Planning and Urban Development Department

Subject: IOZ Design Review – 22 Bramhall (Maine Medical)
Written by: Caitlin Cameron, Urban Designer
Date of Review: Thursday, December 13, 2018

This memo summarizes the applicable design guidelines and staff review for the project at 22 Bramhall Street – Congress Street Medical Building. This project is reviewed according to the adopted IOZ IDP and Regulatory Framework standards.

Fig.5.19 Computer-generated shadow study / Existing conditions on December 21, noon

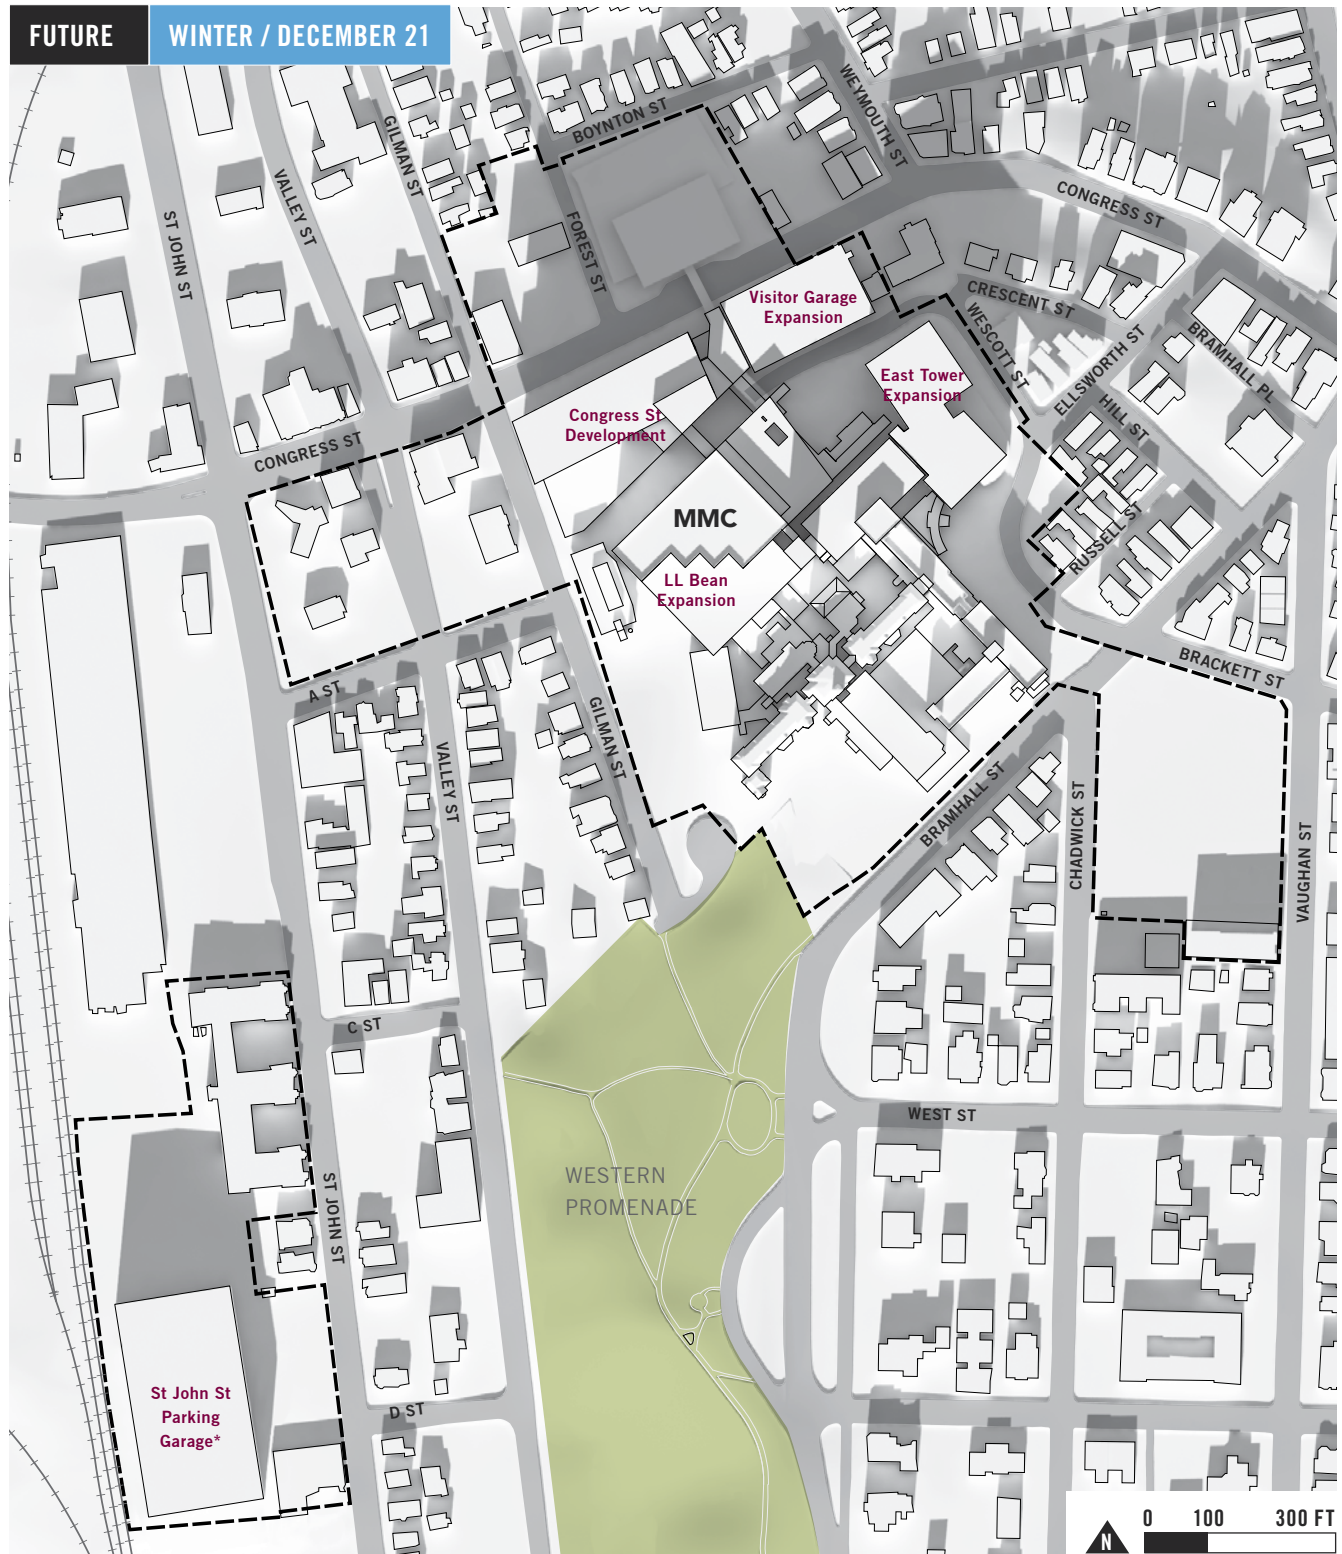
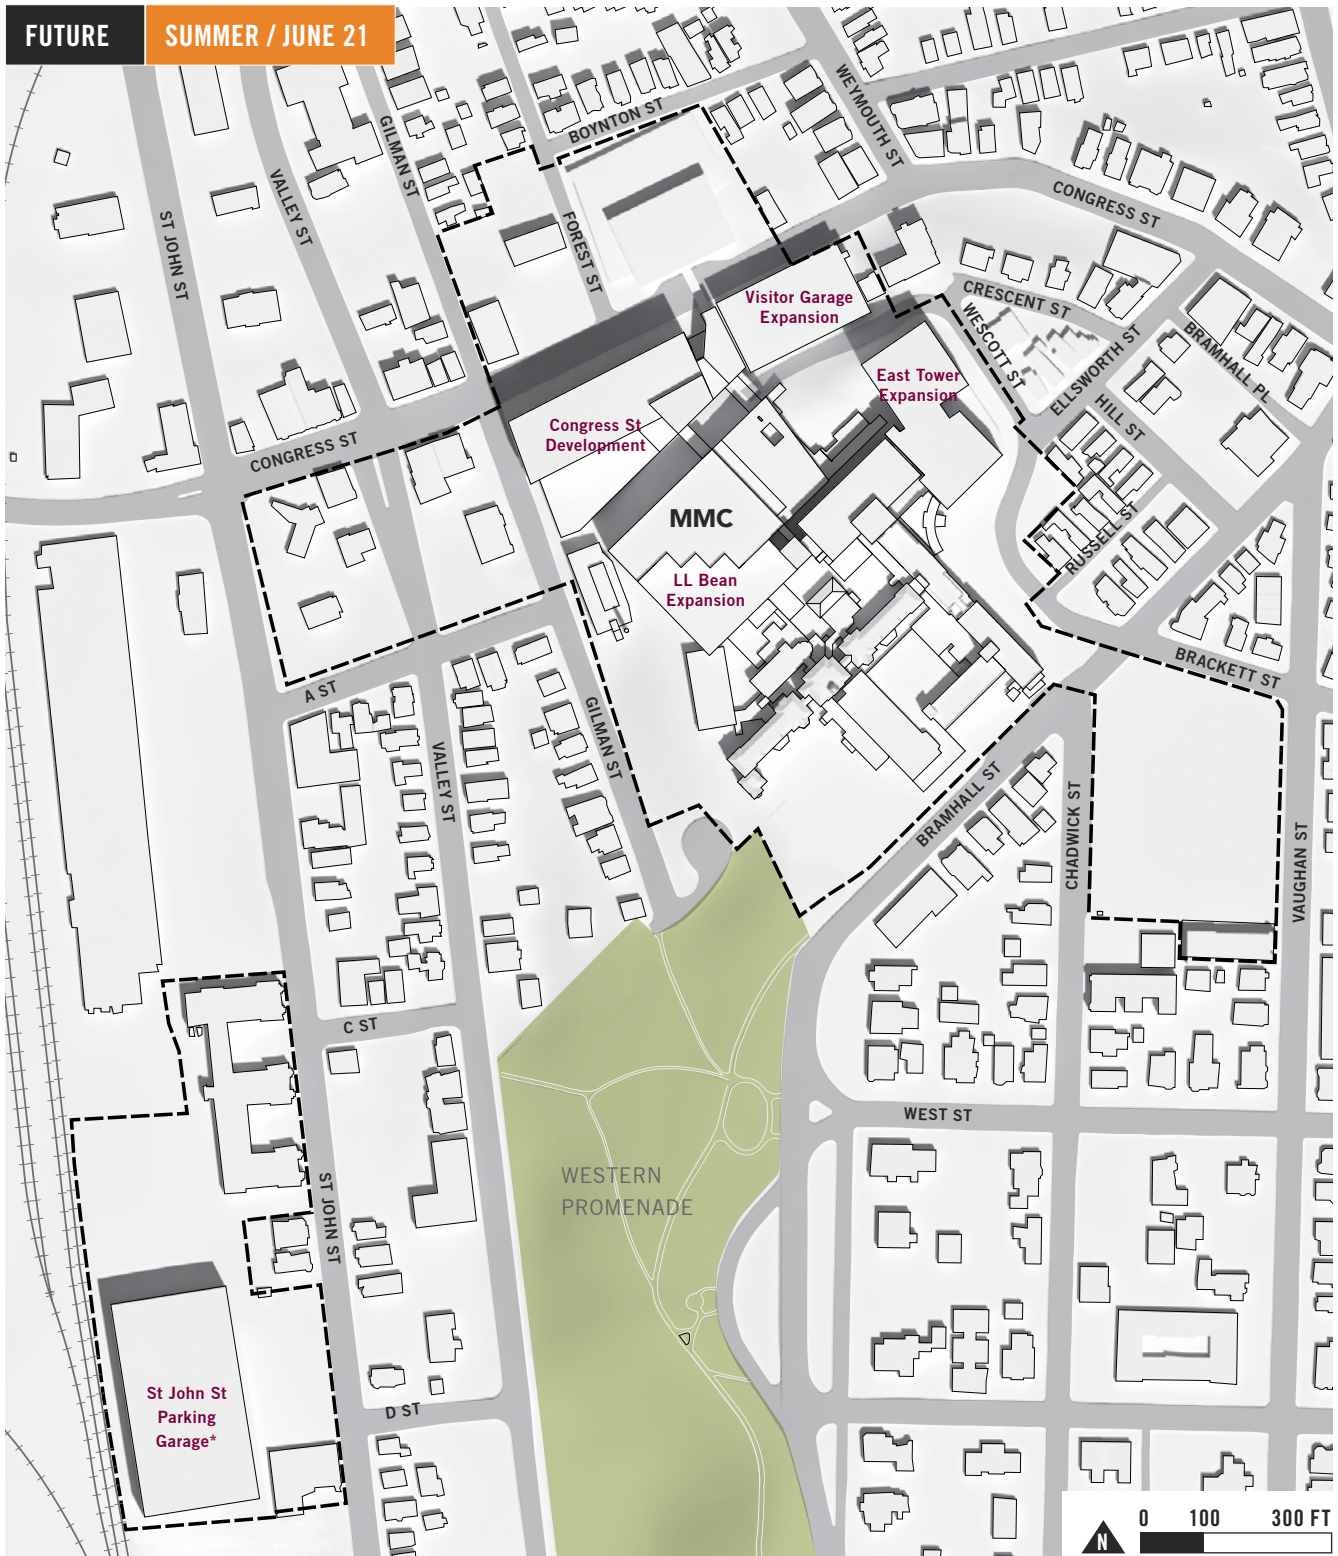
Minimizing Shadow Impacts - Shadow impacts were evaluated as part of the IDP process. The proposed project is shorter but also closer to the street than the existing garage. The impacts as shown in the IDP figures 5.17 through 5.20 show that **additional shadow is created on the street year round and also for one residential building in the winter by this building.**
